Ice Pond Drive Subdivision  
Response to Comments  
Stormwater Management Review:

The following are responses to comments provided by Woodard & Curran for their review of the Stormwater management design for the Ice Pond Drive subdivisions off of Ledgewood Drive.

4 GRASSED UNDERDRAINED SOIL FILTER - TYP. CROSS SECTION
SCALE: N.T.S.

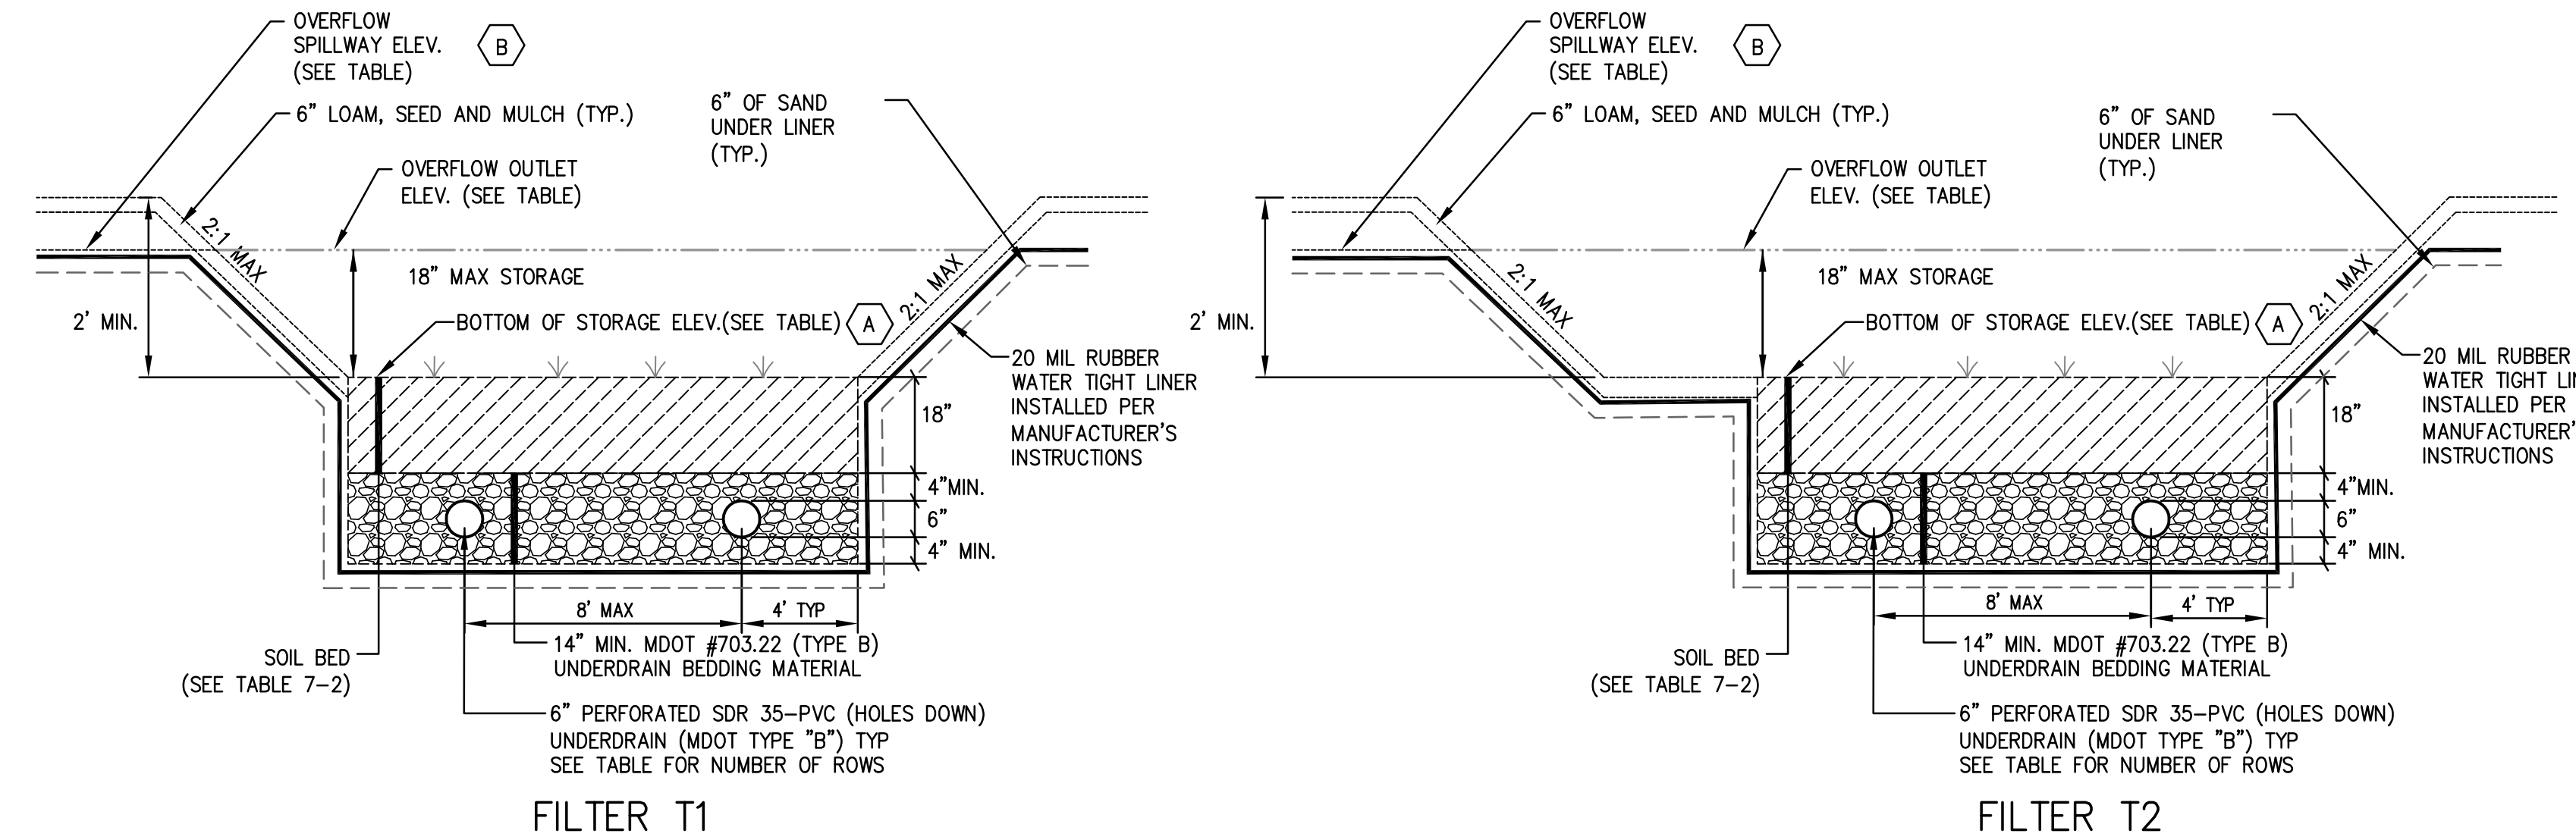
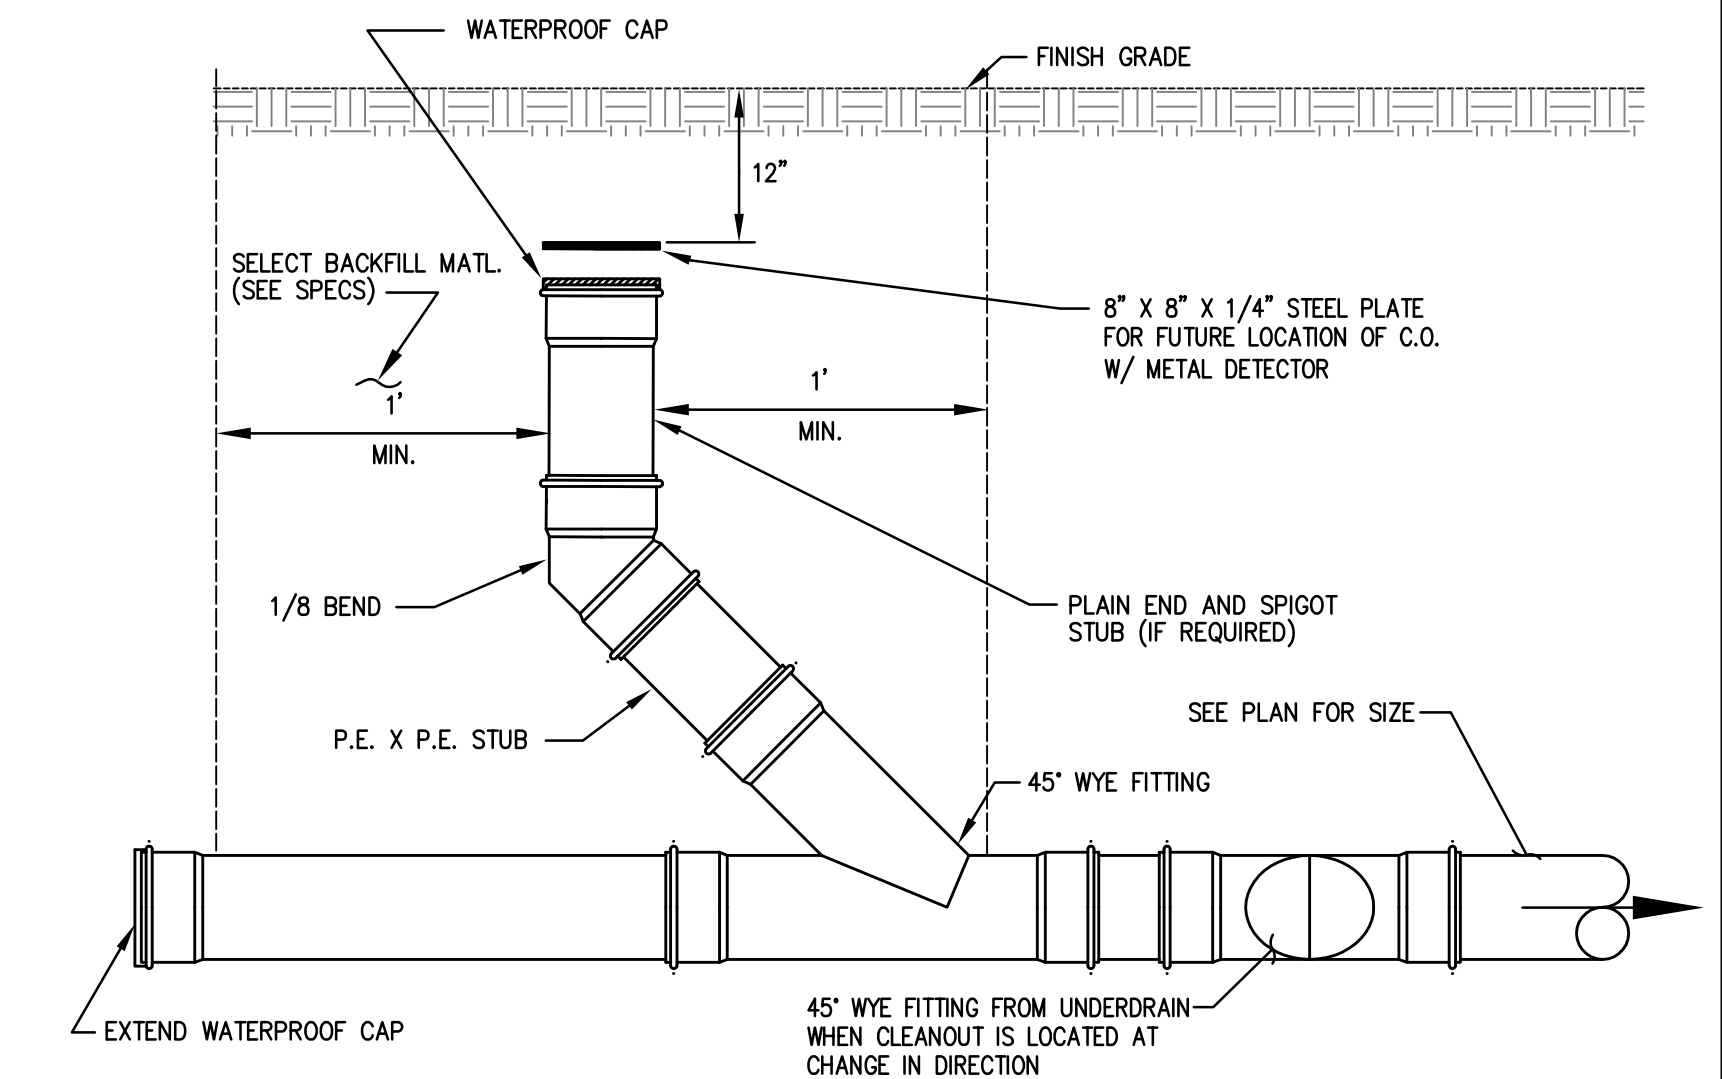
*1)b)i)(3): The Grassed Underdrained Soil Filter detail on C-302 should include a geotextile fabric between natural soils and constructed media.*

Response: Based on test pit information, a liner is now required for these filters. Because the liner is now proposed, we have not included a geotextile fabric.

*5) Sheet C-201 includes a call-out for an "interception swale" on the north side of Lot 8. It appears that this features is a berm, not a swale; please clarify.*

Response: For clarification, the "interception swale" has been renamed "diversion berm" on both the plan and detail.
